Our Reference: SYD12/01384
Your Reference: SSD 5373
Contact: Ravi Ravendra
Telephone: 8849-2540

**SYDNEY
REGIONAL
DEVELOPMENT
ADVISORY
COMMITTEE**

**PROPOSED MATERIAL SCIENCE ENGINEERING BUILDING
UNSW, ANZAC PARADE, KENSINGTON**

Figure 8: Proposed vehicle access to new MS&EB. The vehicle shown is a 19 metre articulated truck used for the delivery of Liquid Nitrogen. Waste vehicles are in the classification of medium rigid vehicles.

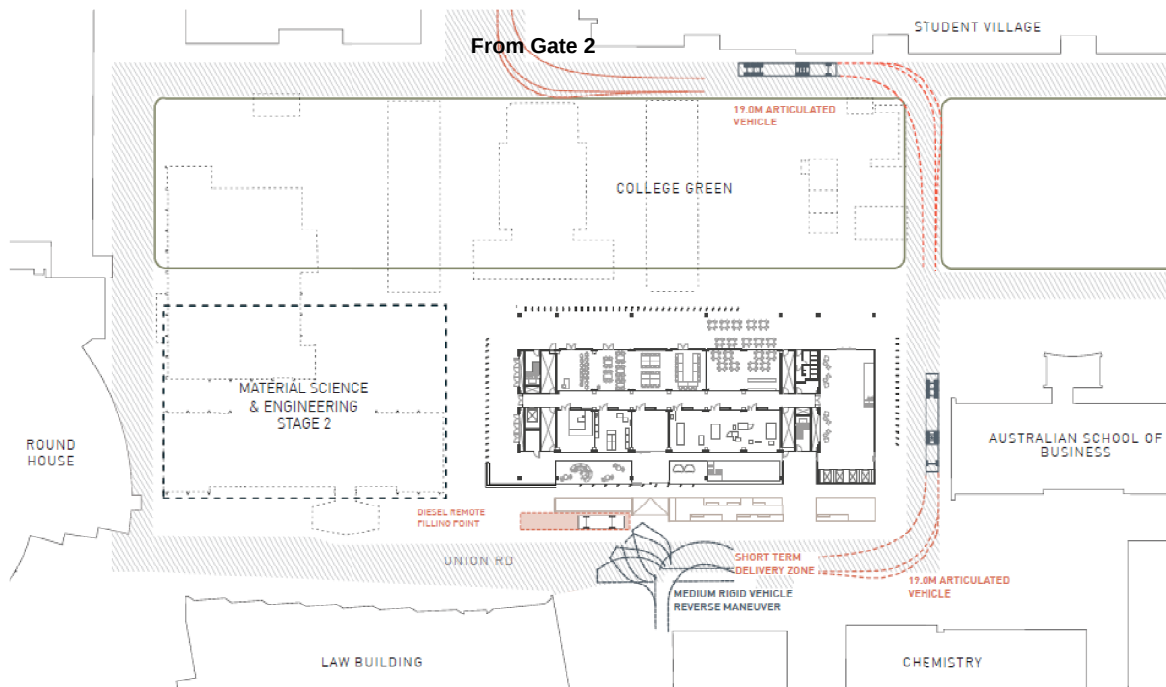
1. The proposed number of parking spaces should be determined by the Department of Planning and Infrastructure in consultation with Council.
2. The swept path of the longest vehicle (including garbage trucks) entering and exiting the subject site, as well as manoeuvrability through the site and local road network, shall be in accordance with AUSTROADS. In this regard, swept path plans should be provided to DoP&I and referred to Council for review and comment.
